From: [REDACTED]
Sent: [REDACTED]
To: [REDACTED]
Subject: RE: Planning Application WA/43/20/HH
Categories: Green Category

Relocated Gates plus Security Fence & 3 Small Fences

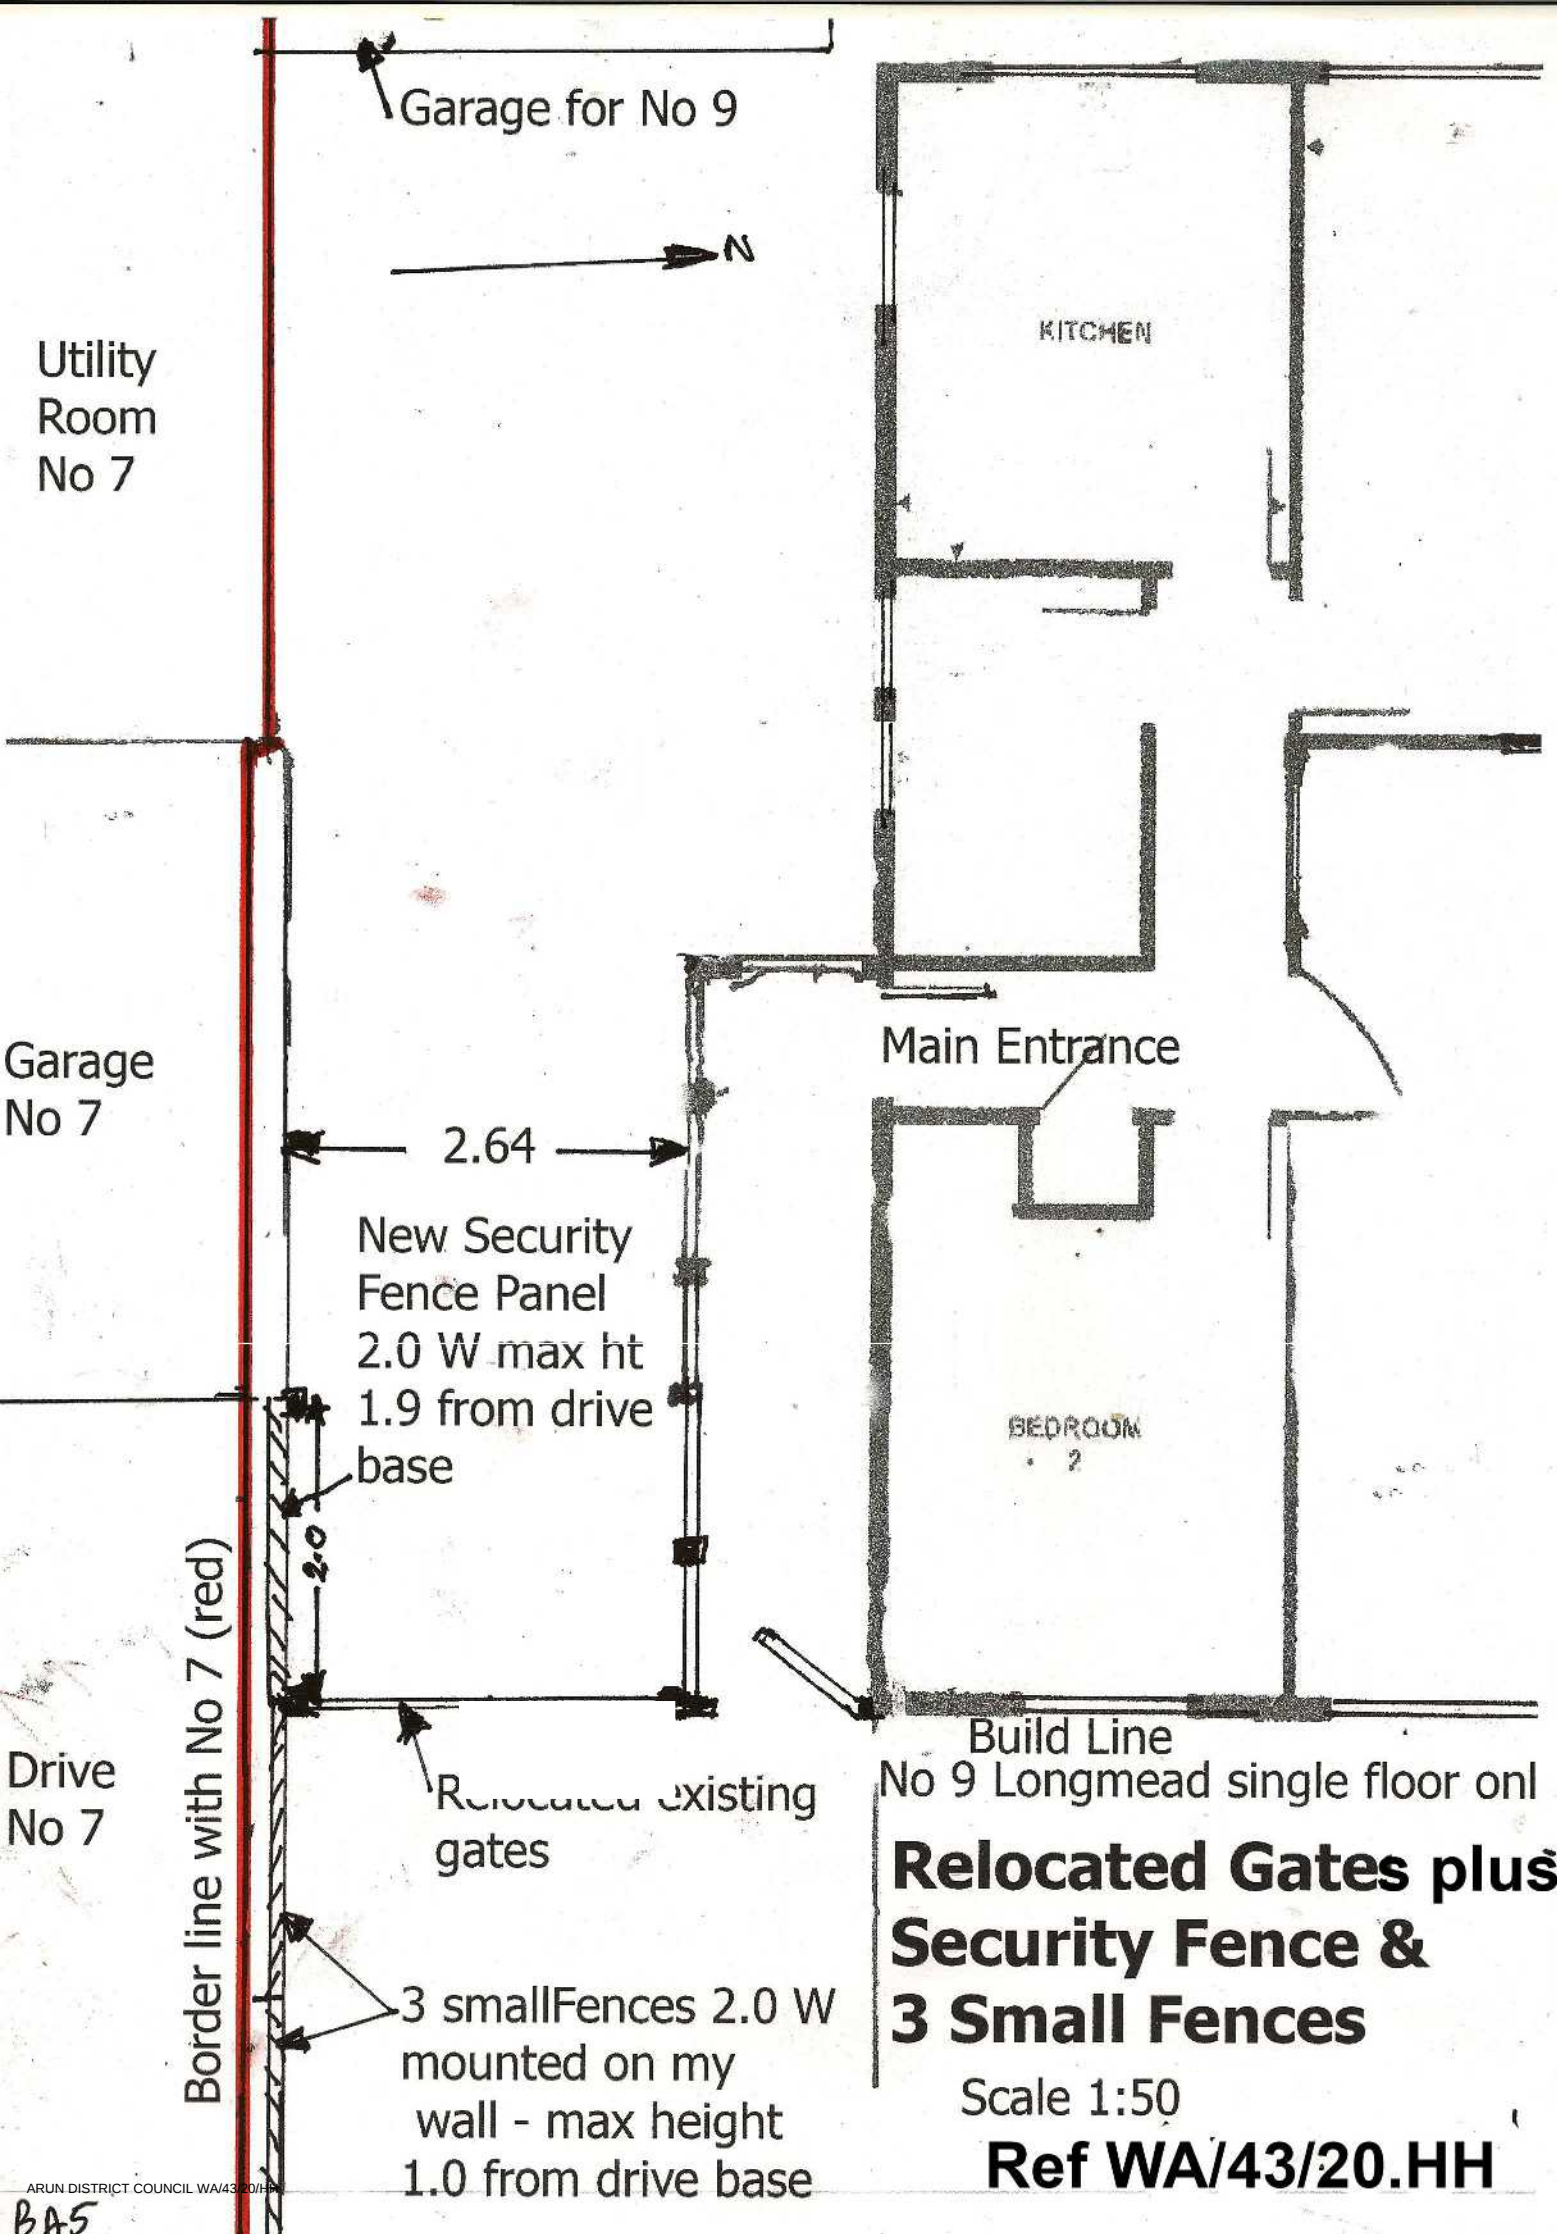
Thank you for your email, the plans are fine however the floor plans are measuring to 1:50 rather than 1:500, with your permission I can amend the scale for you.

Hello Sian Thank you for your quick reply and observation. I most certainly will accept your kind offer to amend the scale.
